Technical Memorandum

Quality Information	
Project:	242-244 Beecroft Road, Epping (SSD 8784)
Project Number:	SCT_00045
Document Name:	Post Exhibition Responses to Traffic and Parking Addendum Memorandum
Date:	23 October 2019
Prepared:	Shawn Cen, Senior Consultant
Reviewed:	Jonathan Busch, Associate Director
Authorised:	Andy Yung, Associate Director

This memo is an addendum to the original report, modifying the traffic and parking content to respond to comments received during public exhibition under the category of Traffic, Transport and Parking as well as a number of other traffic related miscellaneous comments.

DRAWING TITLE	CONCEPT PROPOSAL LOWER GROUND PLAN
SCALE:	PROJECT NORTH
1:500 @A3	
DRAWING NUMBER	REVISION
5	3

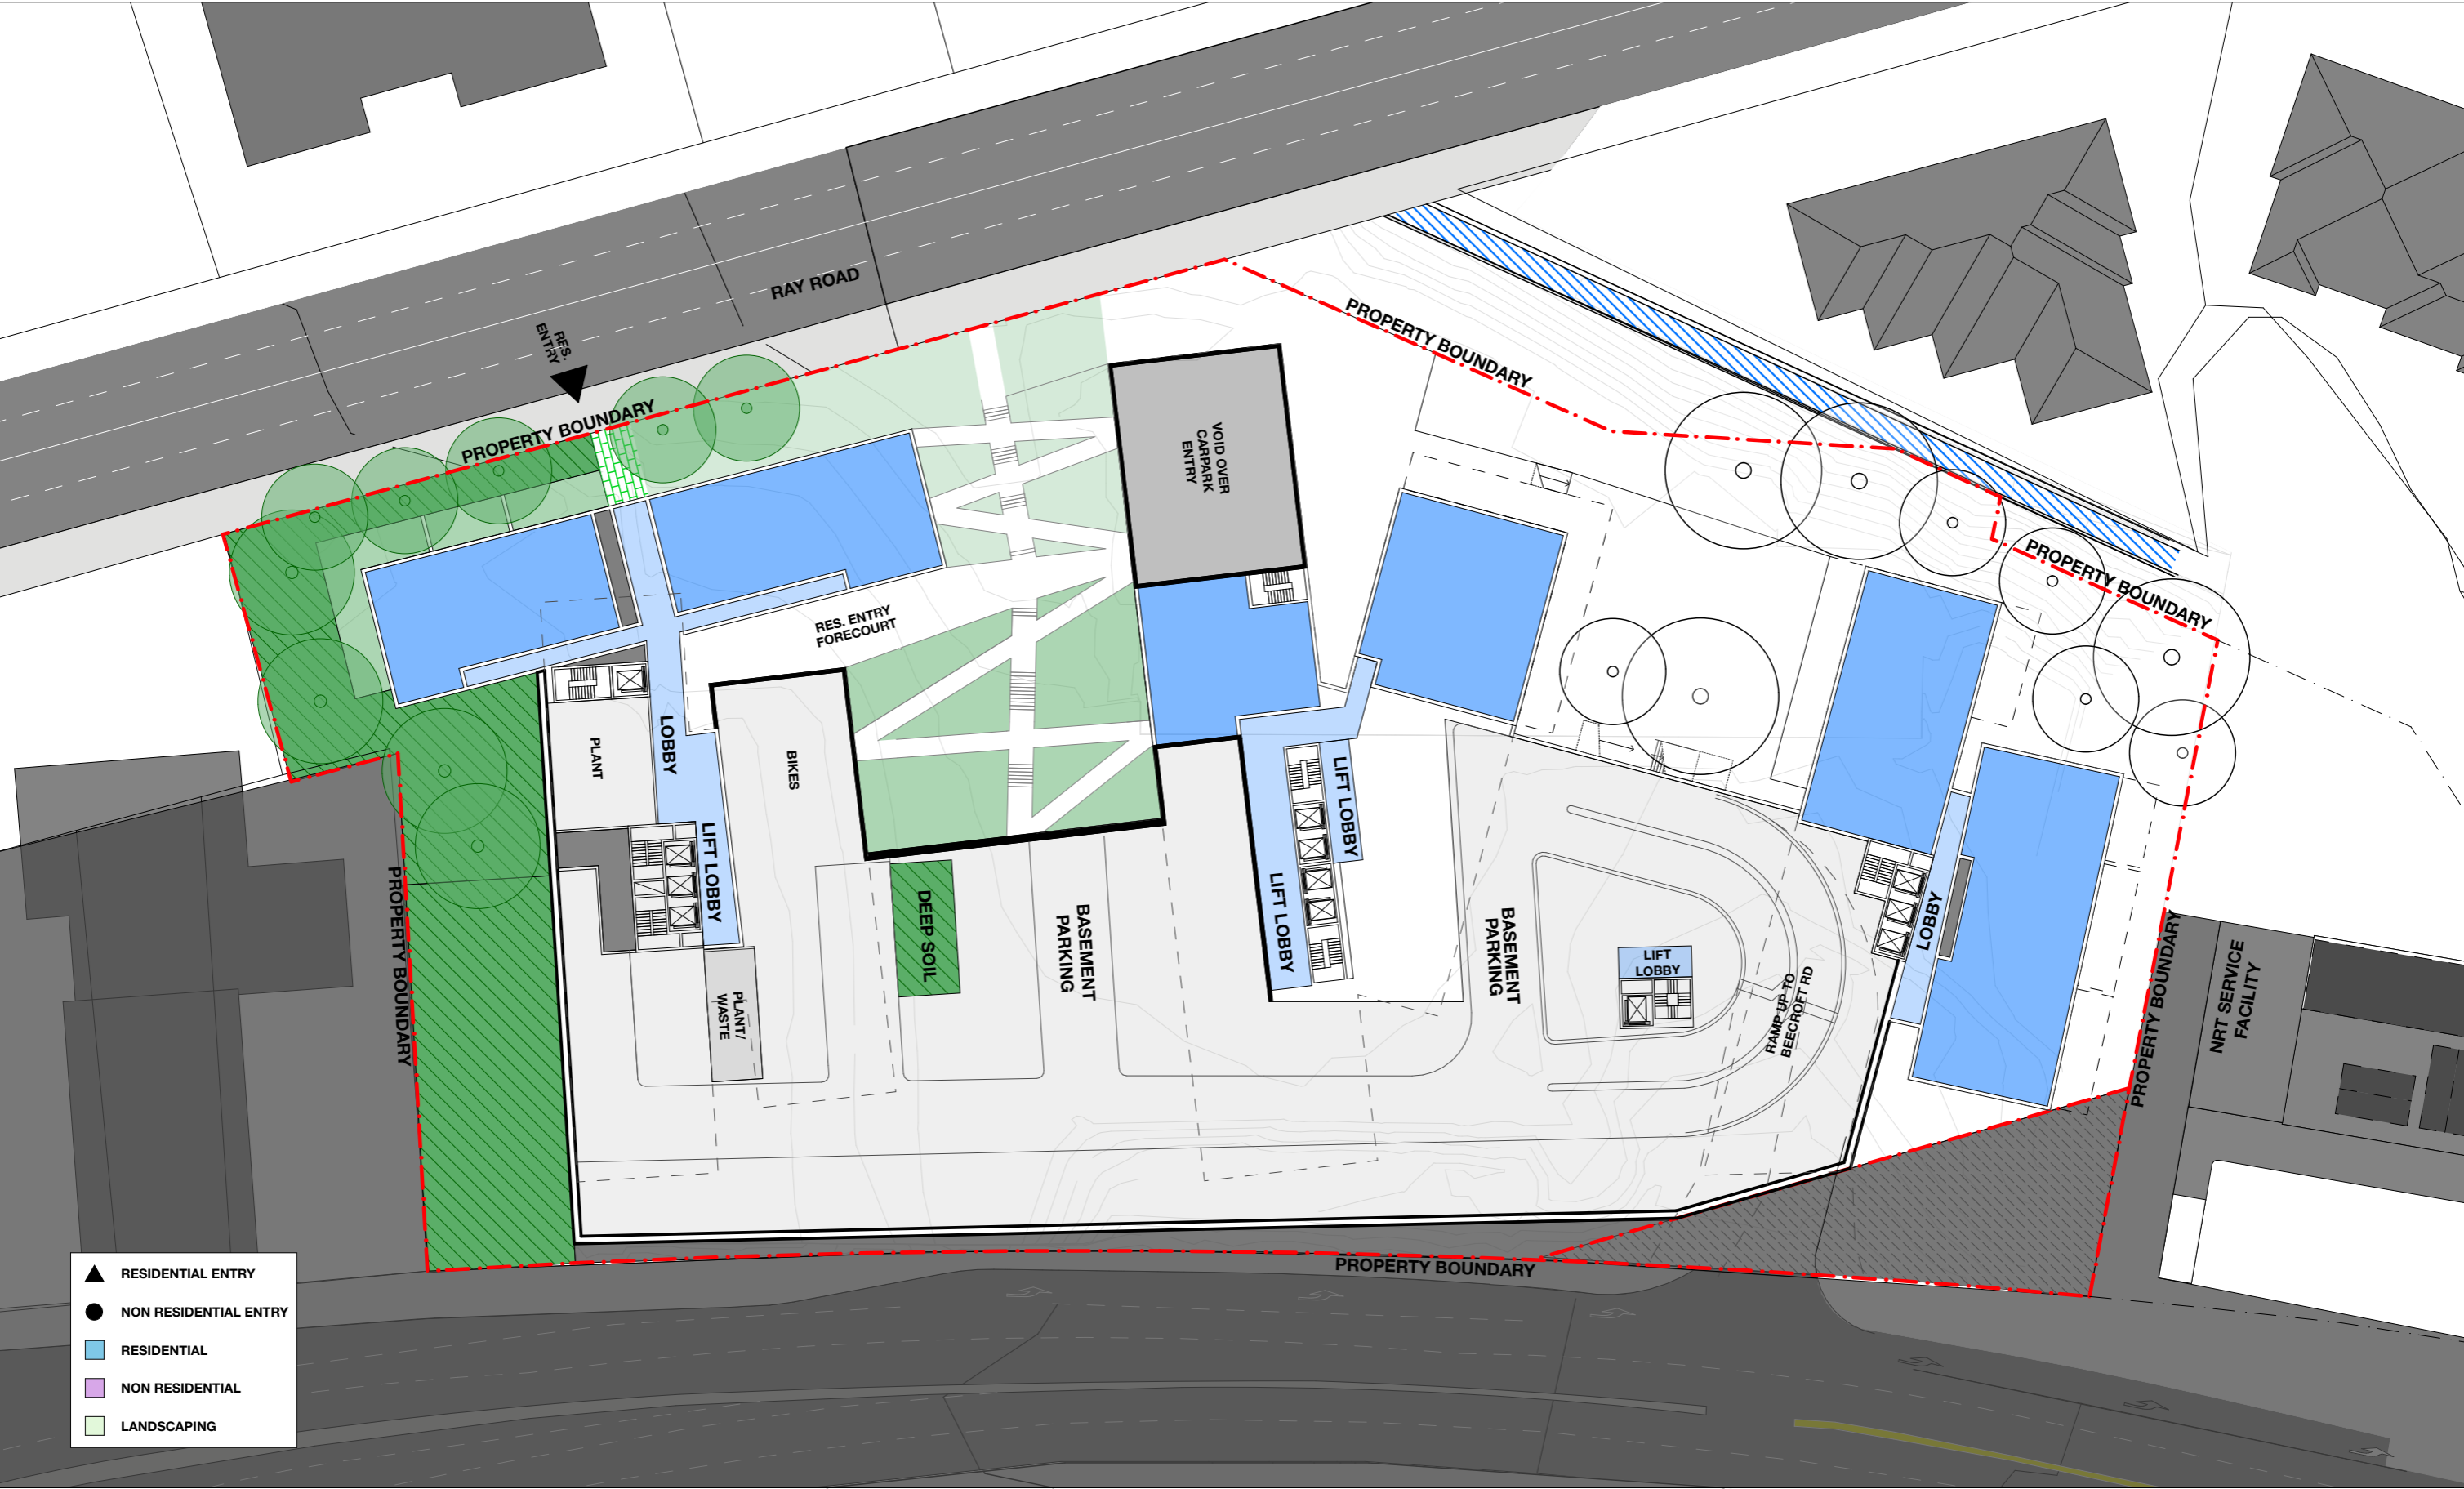
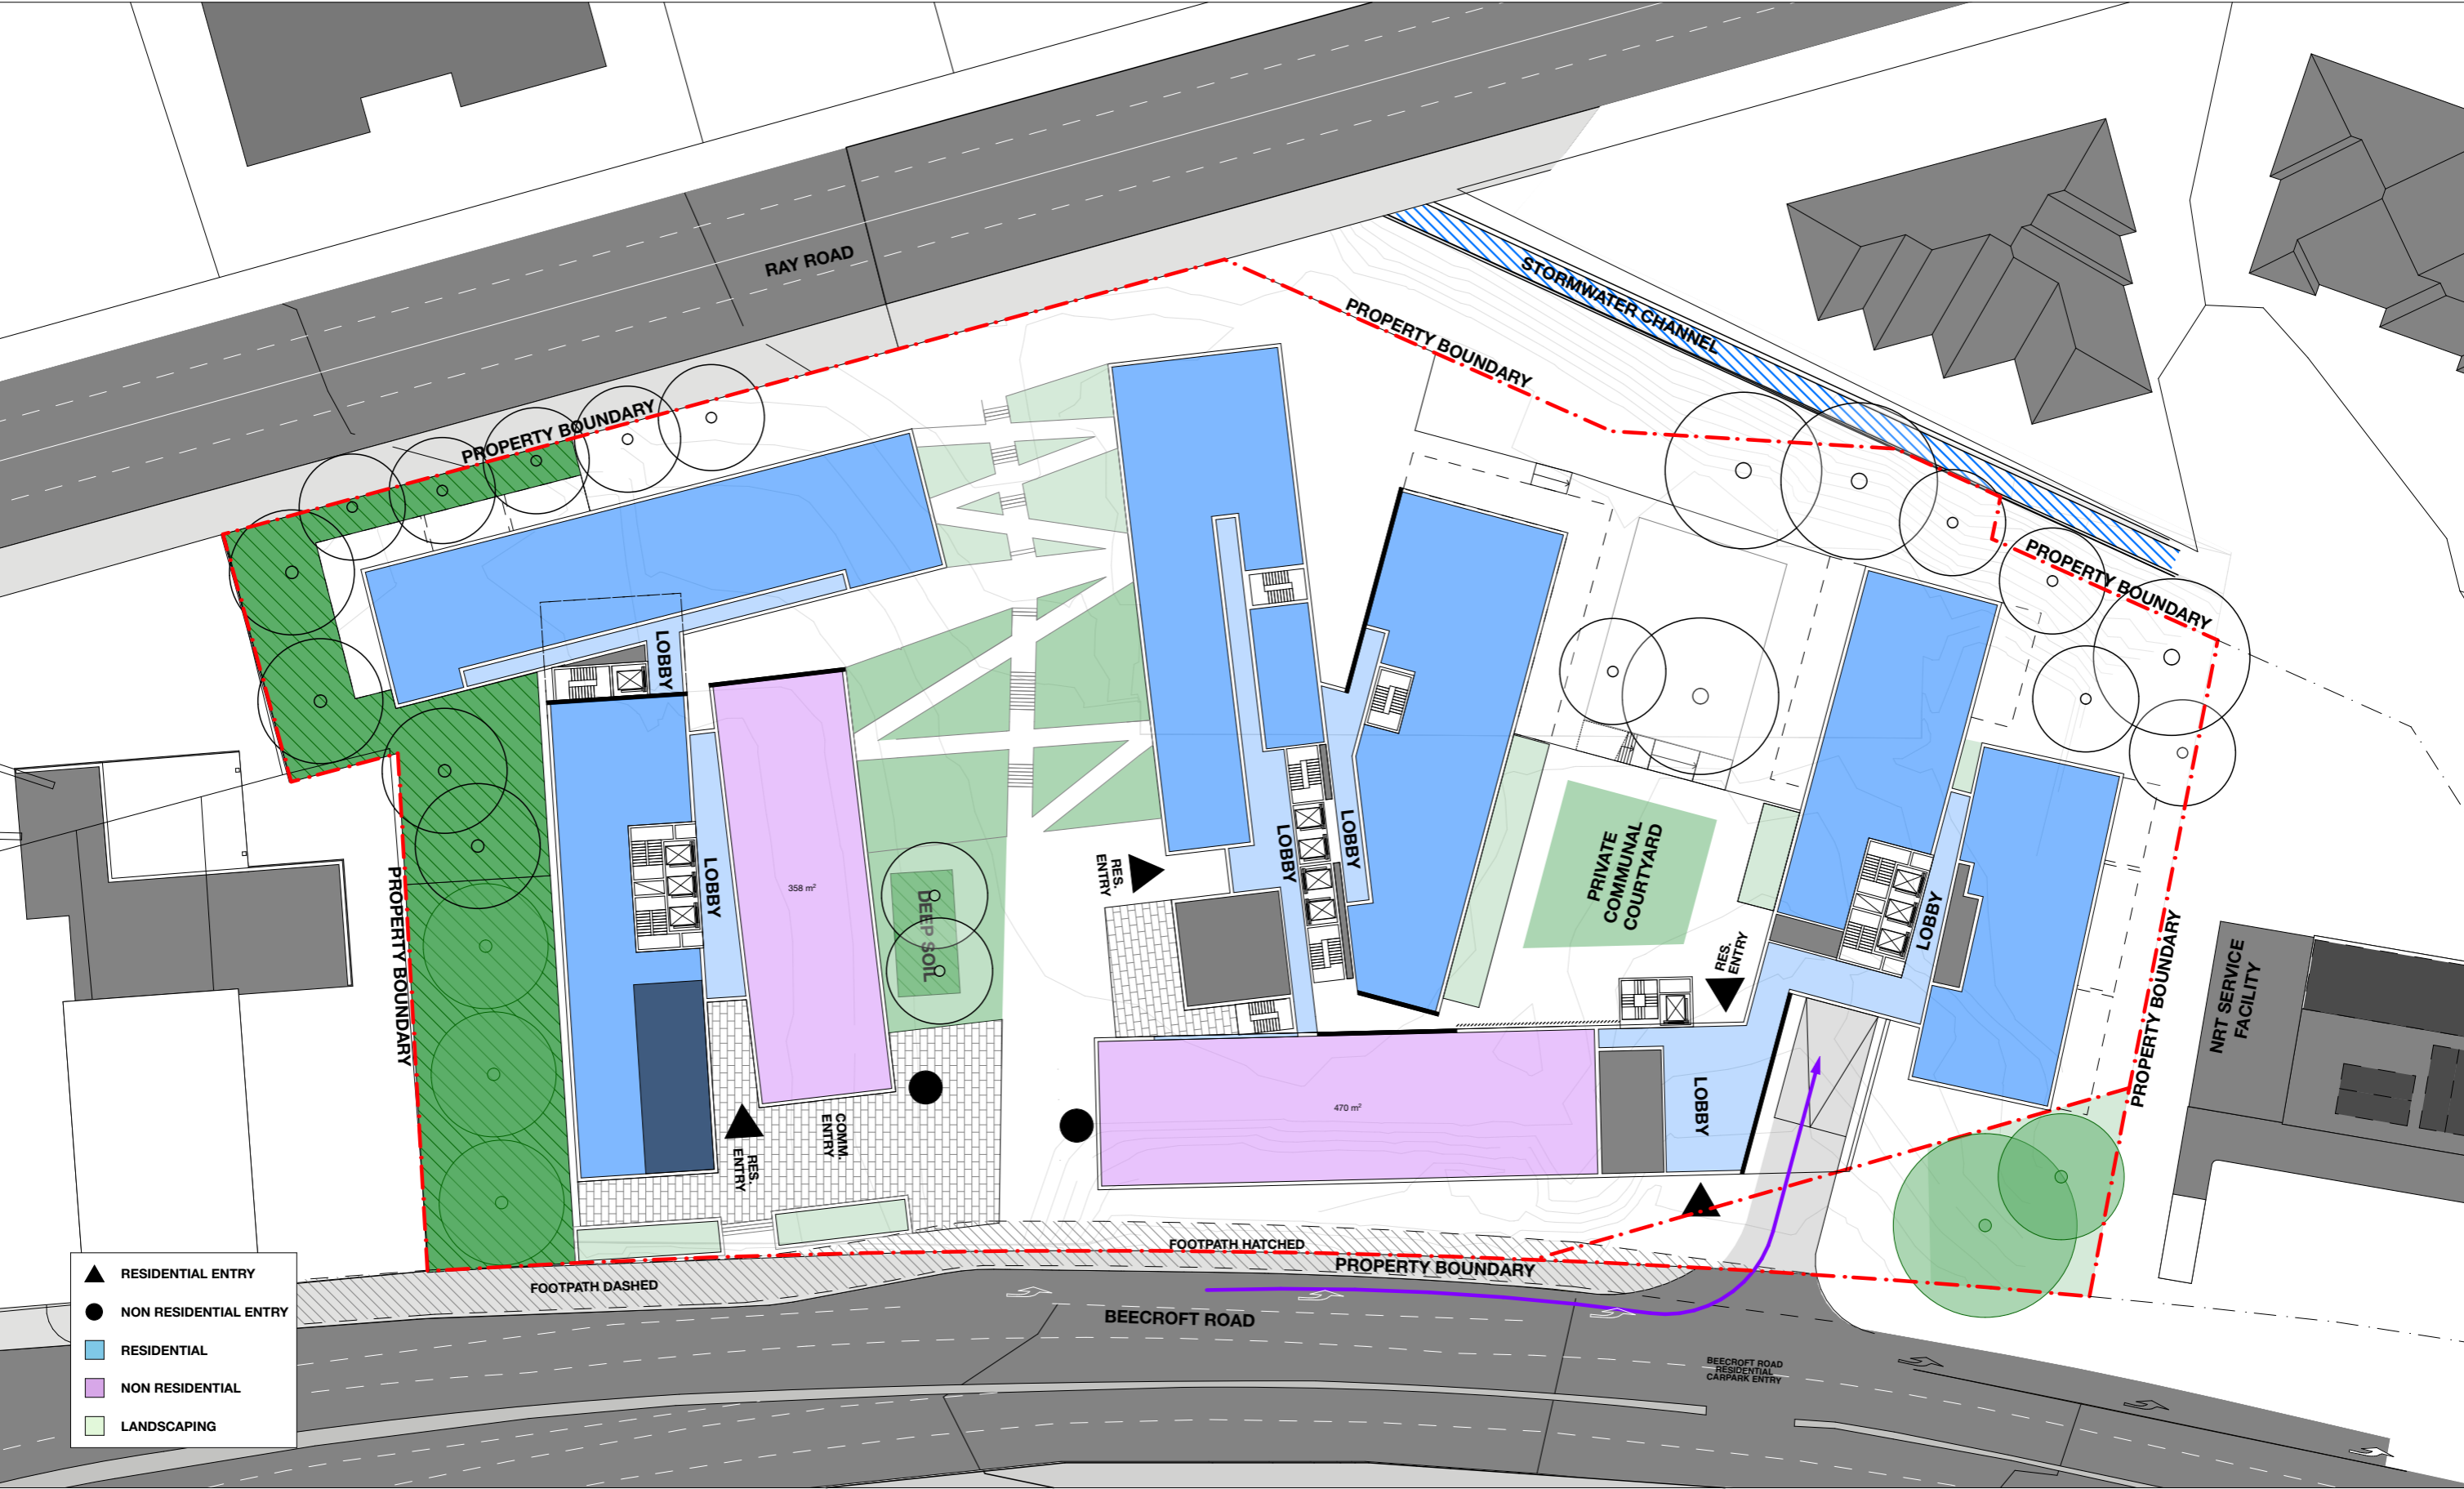
Reference	Post-exhibition comments	Responses
		<p data-bbox="734 240 1301 264">Figure 5 Proposed lower ground and ground floor plans</p>  <p data-bbox="734 1121 1088 1137">INDICATIVE LOWER GROUND FLOOR PLAN 1:1000</p> <p data-bbox="1420 1121 1850 1137">INDICATIVE GROUND FLOOR (BEECROFT ROAD) PLAN 1:1000</p> <p data-bbox="734 1153 1021 1169">Source: Bennett and Trimble, 2019</p>
<p data-bbox="163 1219 248 1243">5. (i)(d)</p>	<p data-bbox="315 1219 680 1326">Impact of the use of the deceleration lane from Beecroft Road to the Sydney Metro Epping Service Facility.</p>	<p data-bbox="734 1219 1995 1297">The proposed access to and from Beecroft Road will be a left in / left out priority intersection to minimise conflicts with traffic on a State arterial road. The concept and the design of proposed access at Beecroft Road has been developed in consultation with Roads and Maritime.</p> <p data-bbox="734 1310 1995 1361">The proposed left in movement on Beecroft Road will be provided via a deceleration lane of approximately 30m long, to allow entering traffic to slow down without interfering with through traffic on Beecroft Road. Speed controls or speed</p>
